Site Info: SpaceX Installation – 7113 Space Village Ave

RE: Building Permit Application for Satellite Earth Station Site Improvements
Site Address: 7113 Space Village Ave, Colorado Springs, CO 80929
APN: 5417001012
Zoning District: Industrial (I-3)
Starlink Project: Colorado Springs, CO GSN-2988

In response to the review comments from EDARP for file number: COM2613

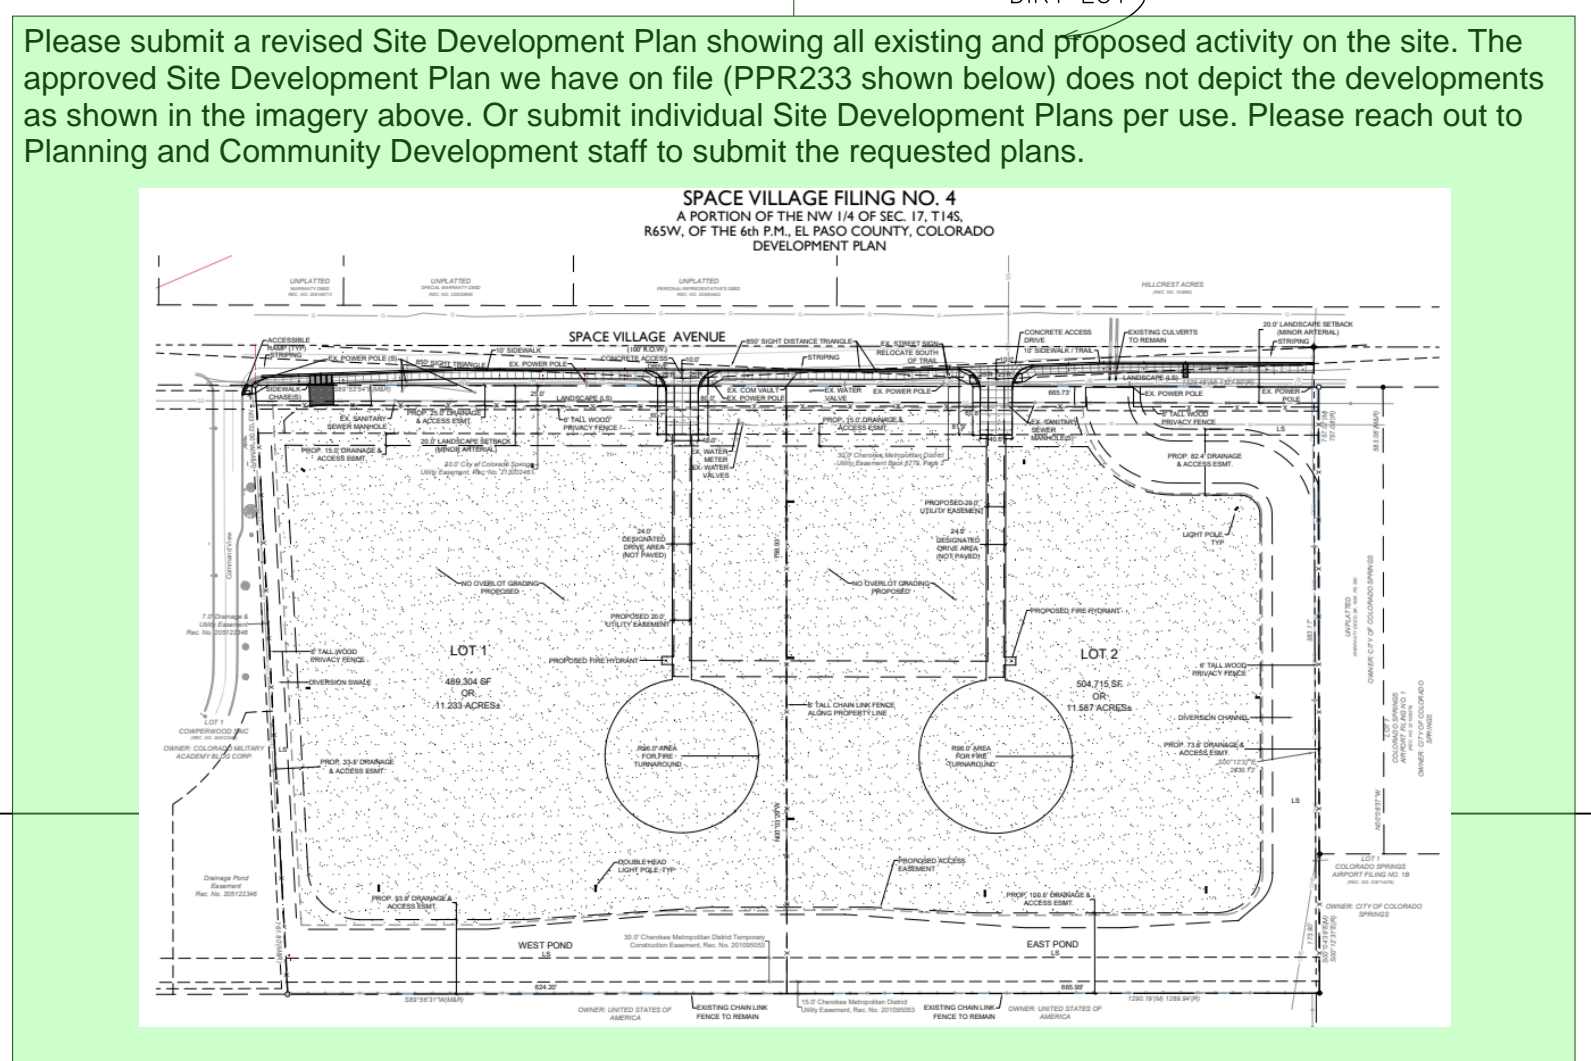
5. The red box drawing on the aerial image represents the only approved land use in the image. The unapproved land use(s) will need to be resolved prior to the approval of this application. A traffic memo may be required as a part of this application and Road Impact Fees will apply.

6. Please submit a revised Site Development Plan showing all existing and proposed activity on the site. The approved Site Development Plan we have on file (PPR233 shown below) does not depict the developments as shown in the imagery above. Or submit individual Site Development Plans per use. Please reach out to Planning and Community Development staff to submit the requested plans.

Response: Please refer to the Correspondence with El Paso County_Development Plans email PDF uploaded as part of this resubmittal package. Per this correspondence, property owners will submit revised Site Development Plans while the Satellite Earth Station proceeds with approvals.

Response: Please refer to the Correspondence with El Paso County_Development Plans email PDF uploaded as part of this resubmittal package. Per this correspondence, property owners will submit revised Site Development Plans while the Satellite Earth Station proceeds with approvals.

PROPOSED SITE PLAN

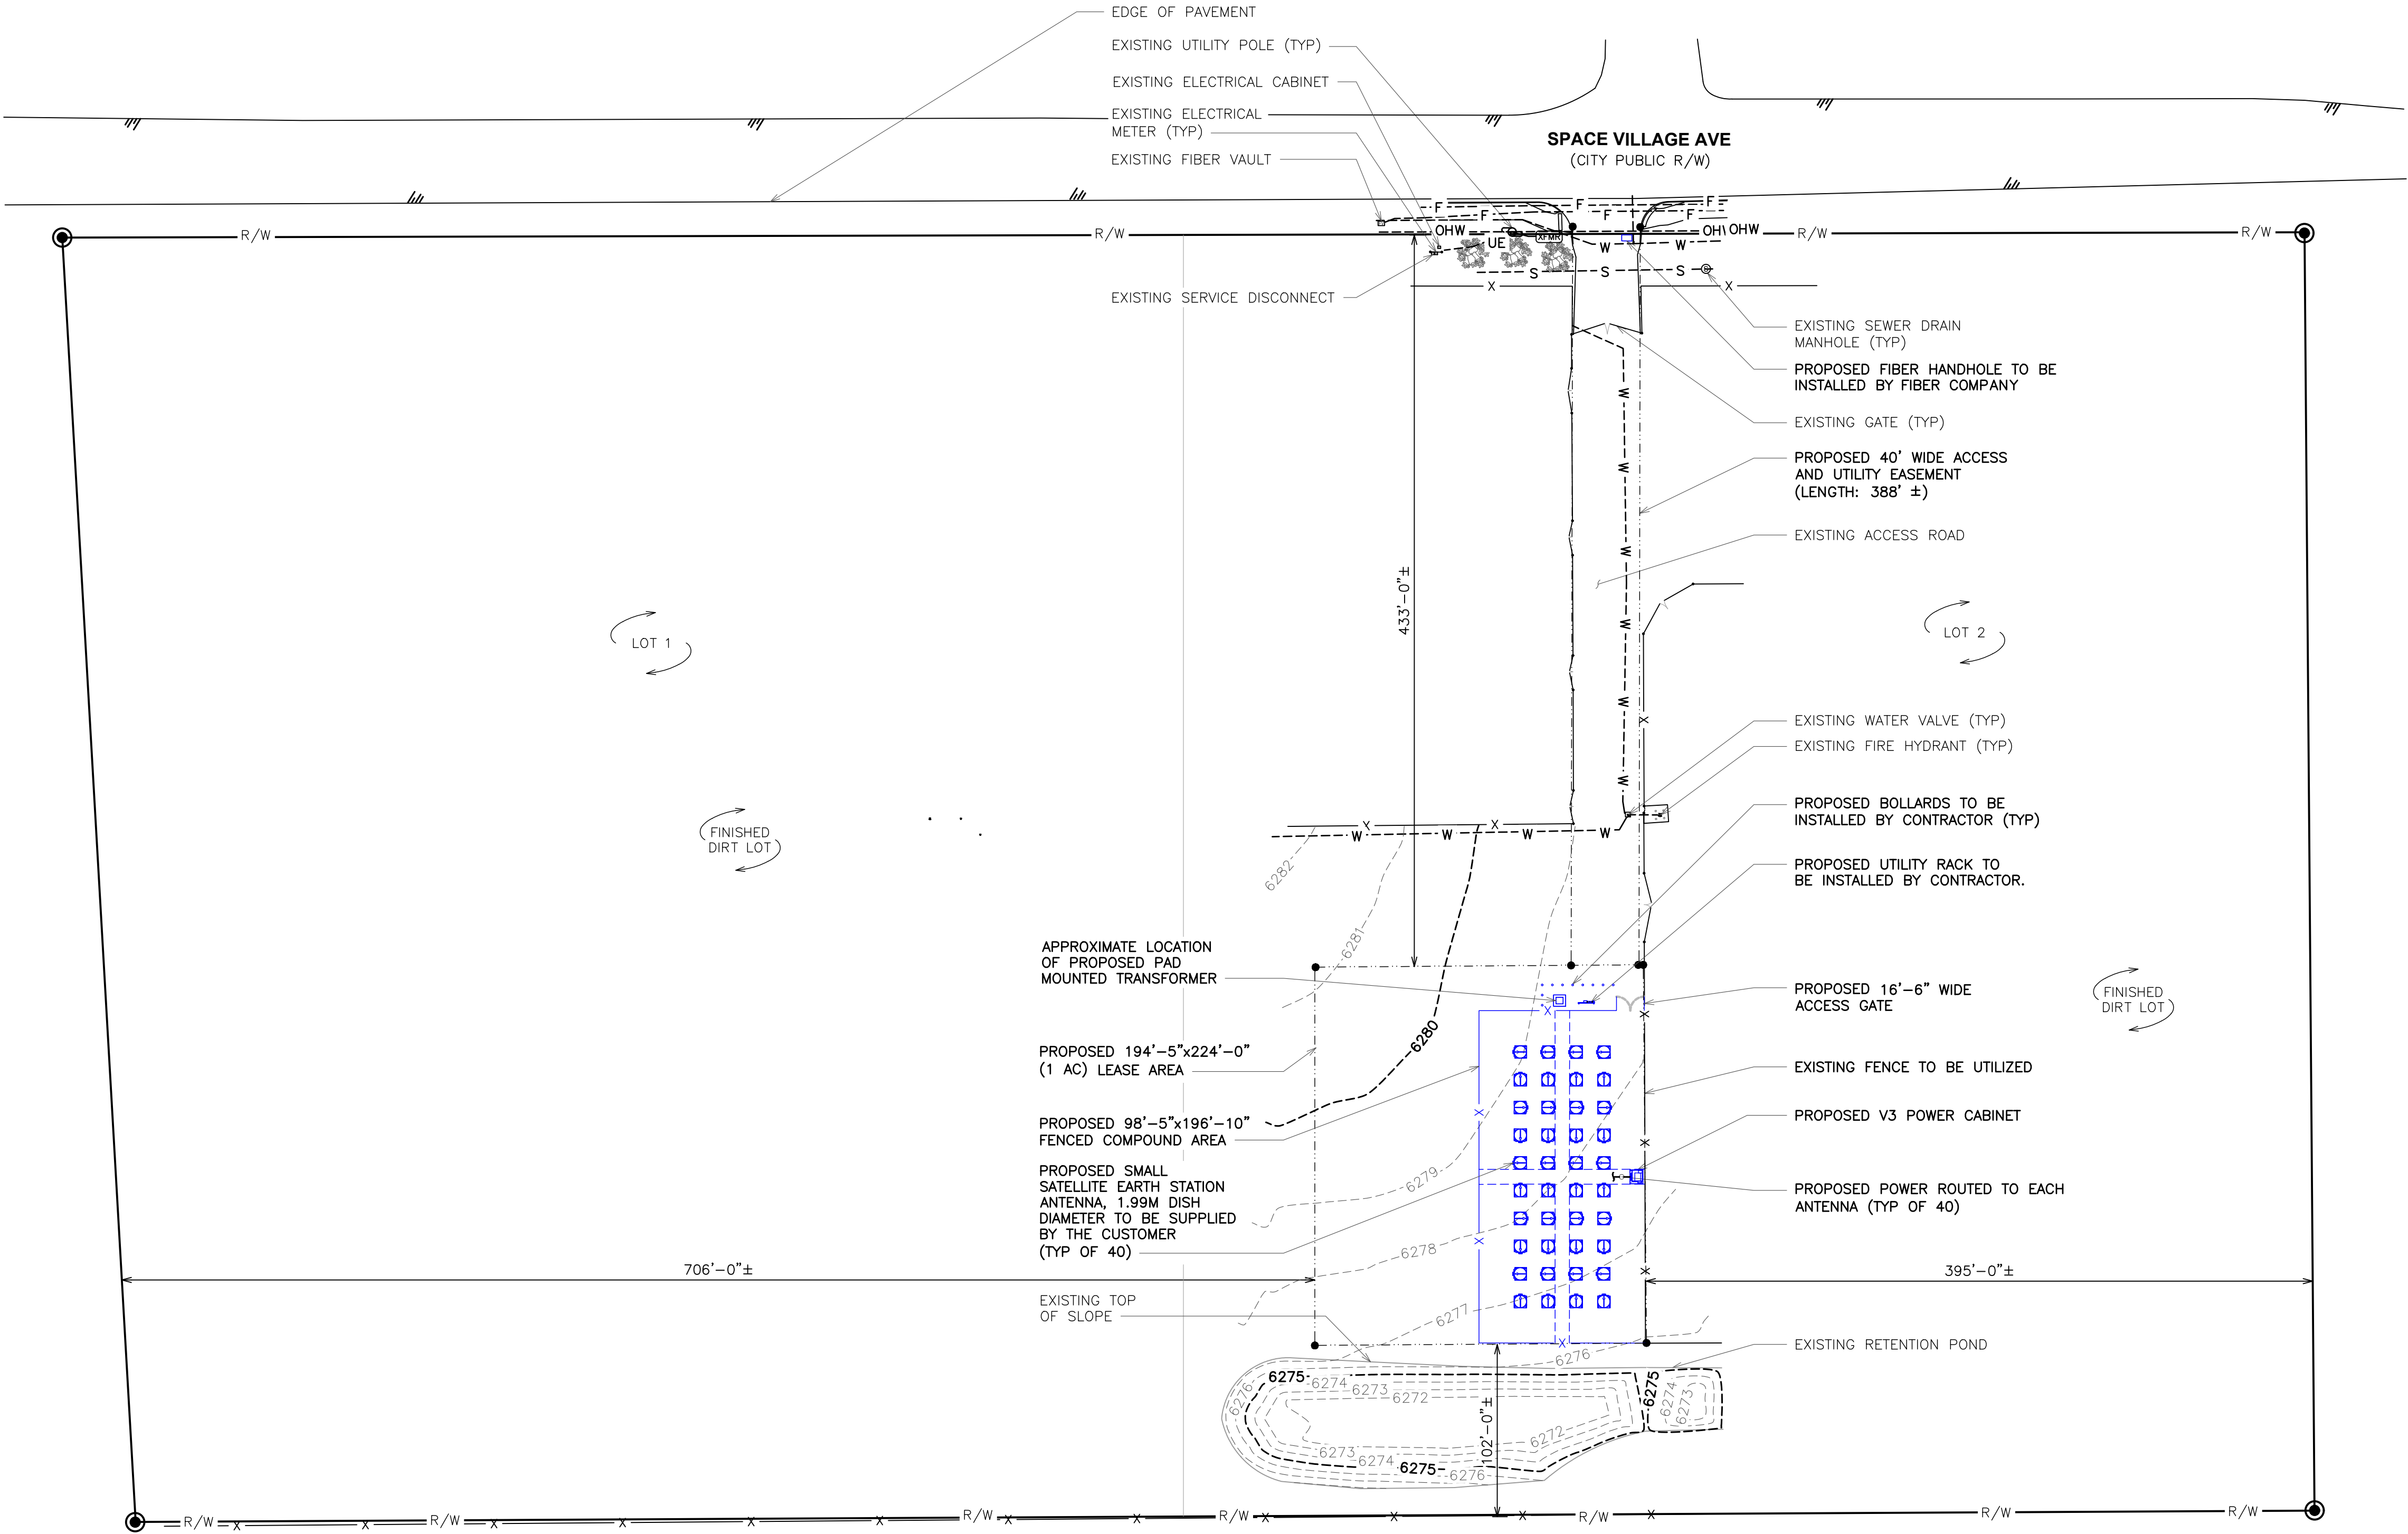
7. Please revise to: City Public R/W

Response: Please refer to revised proposed site plan page C-1.2 for corrected callout.

C-4.1

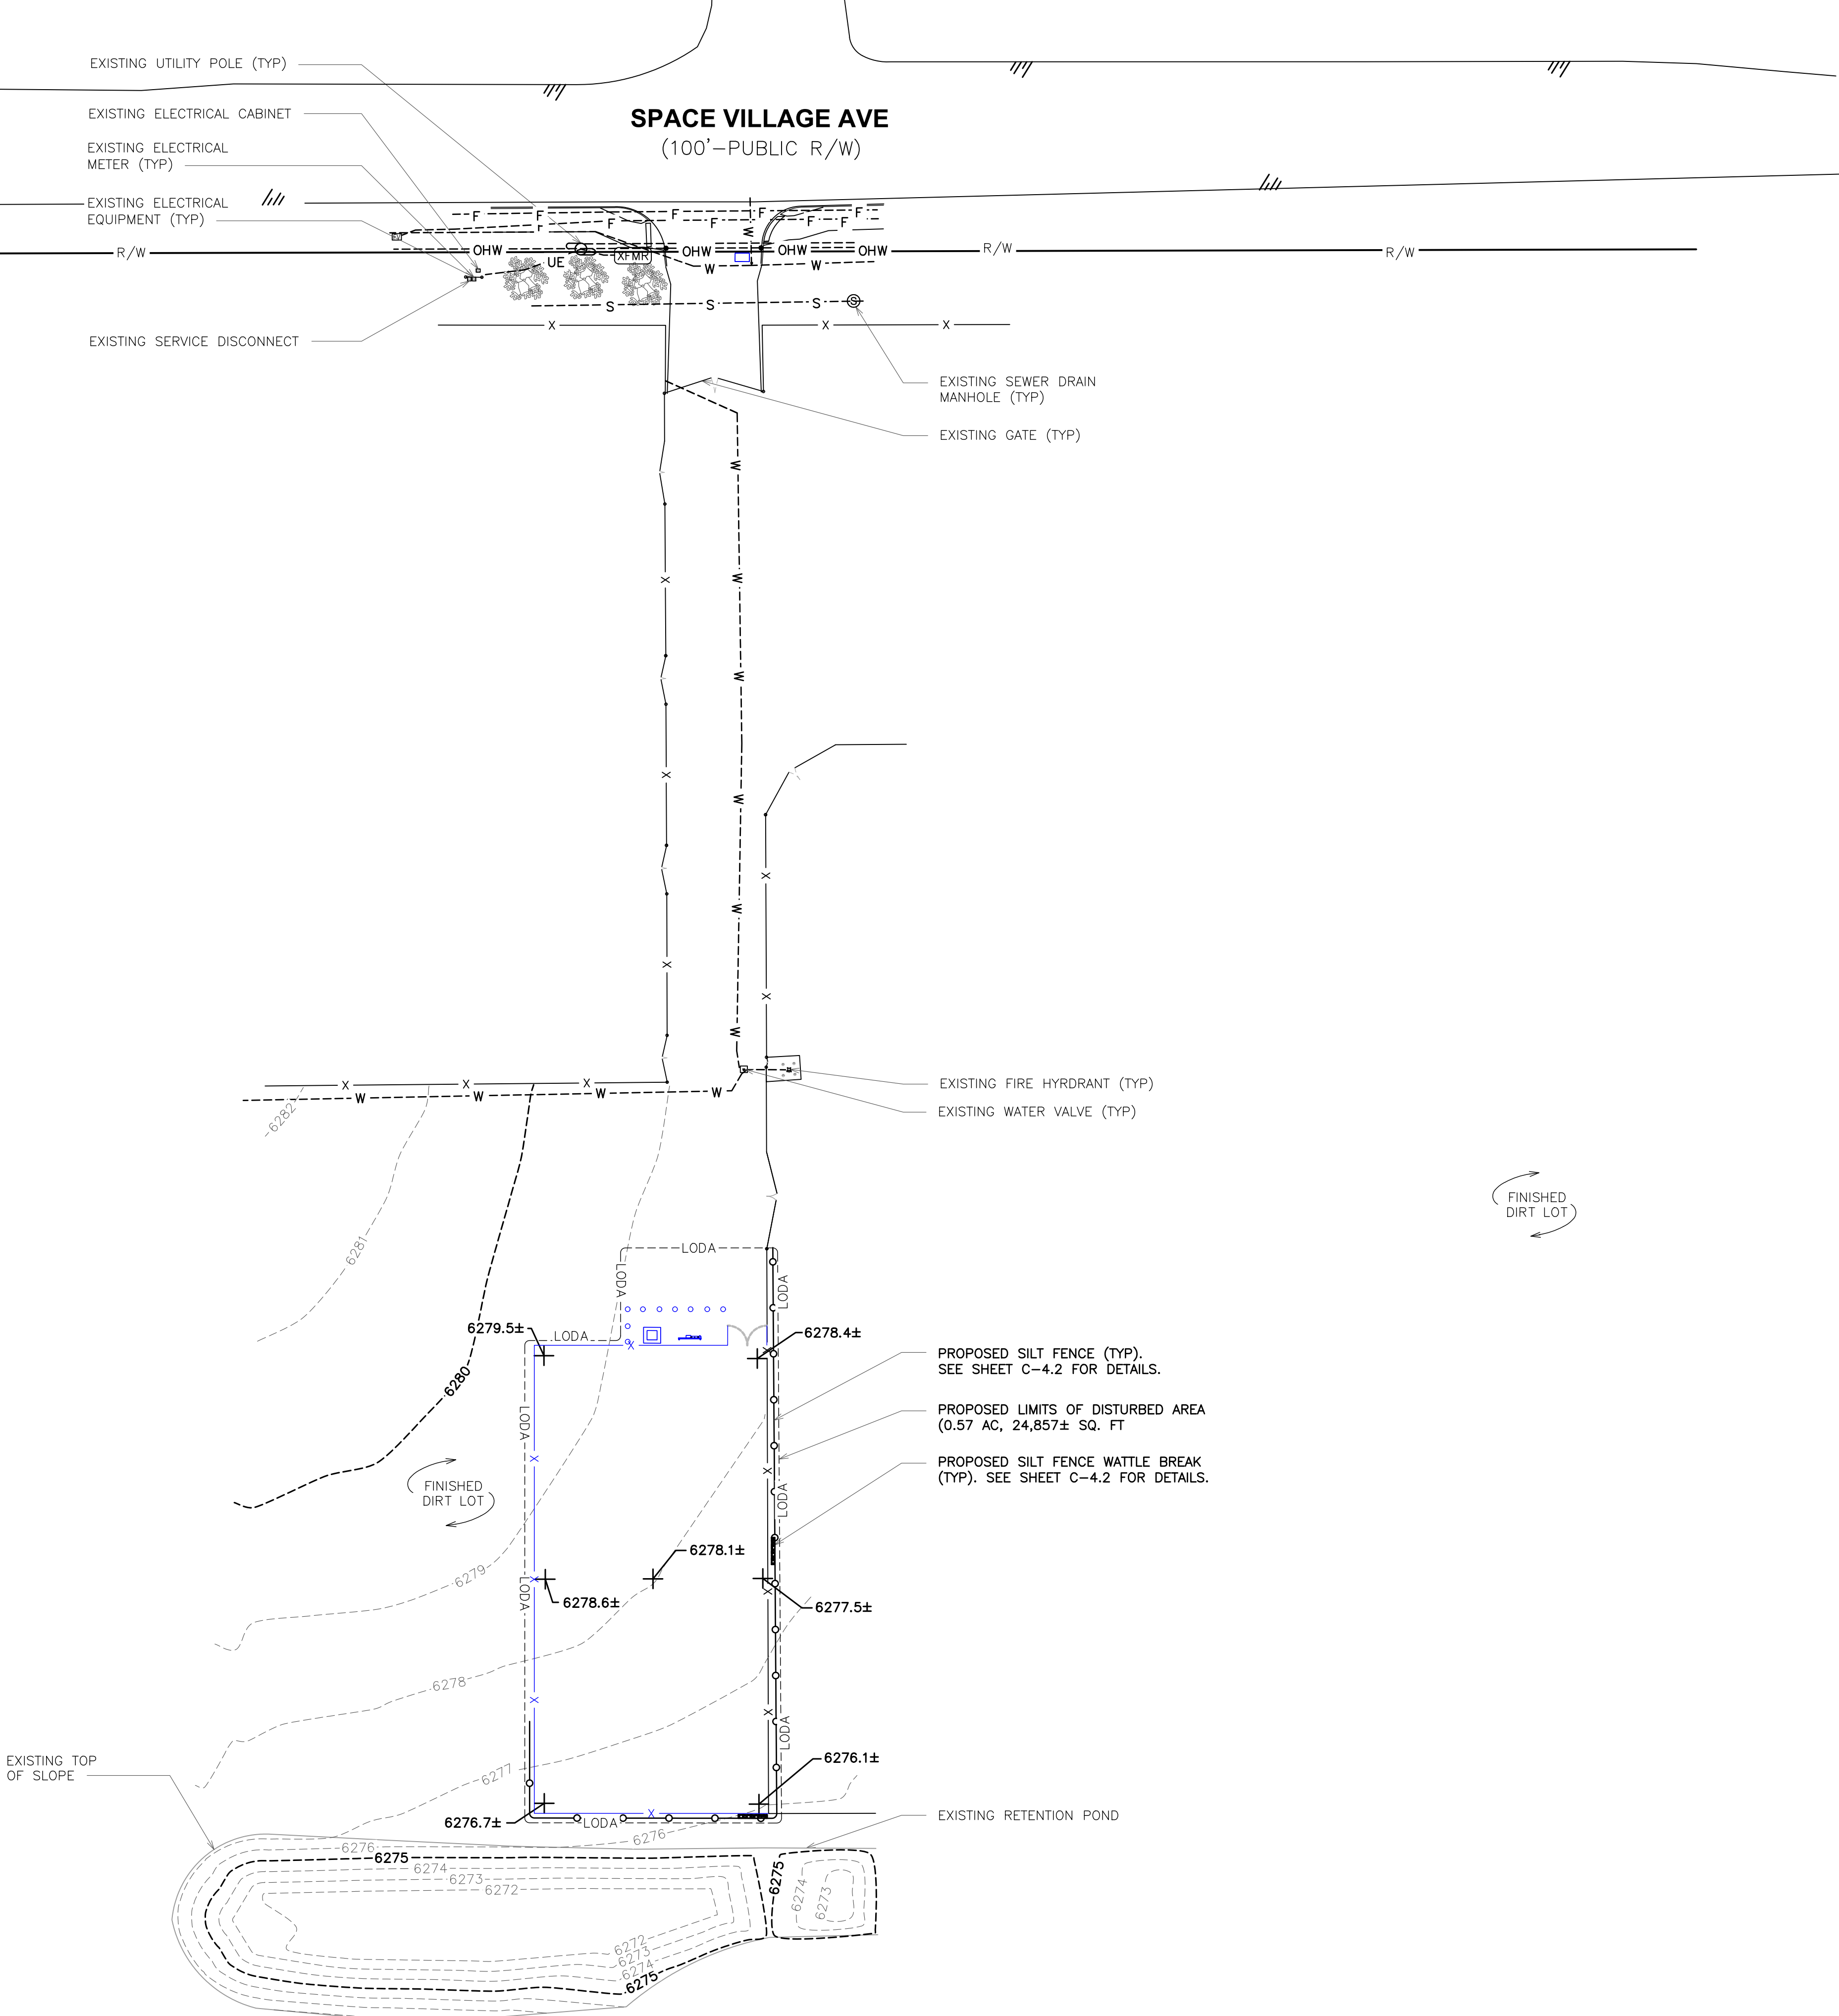
- 1. Please include a statement that stormwater runoff from the proposed satellite antennas will not adversely impact downstream or neighboring properties.**

3. Please provide a statement and reasonable supporting calculations (ex: proposed impervious percentage, proposed peak runoff for 5/100 yr storms, etc) confirming that the proposed development does not exceed the design assumptions of the stormwater pond that provides treatment for the stie. See PCD projects MS2227, PPR2528, and PPR233 for reference.

Response: Please refer to pages C-4.1 and C-4.2 of the site plans comparing existing and proposed runoff coefficients and stormwater peak runoff values. Proposed installation will not adversely impact downstream or neighboring properties.

Response: Please refer to pages C-4.1 and C-4.2 of the site plans comparing existing and proposed runoff coefficients and stormwater peak runoff values that confirm that the proposed development does not exceed the design assumptions of the existing stormwater pond.
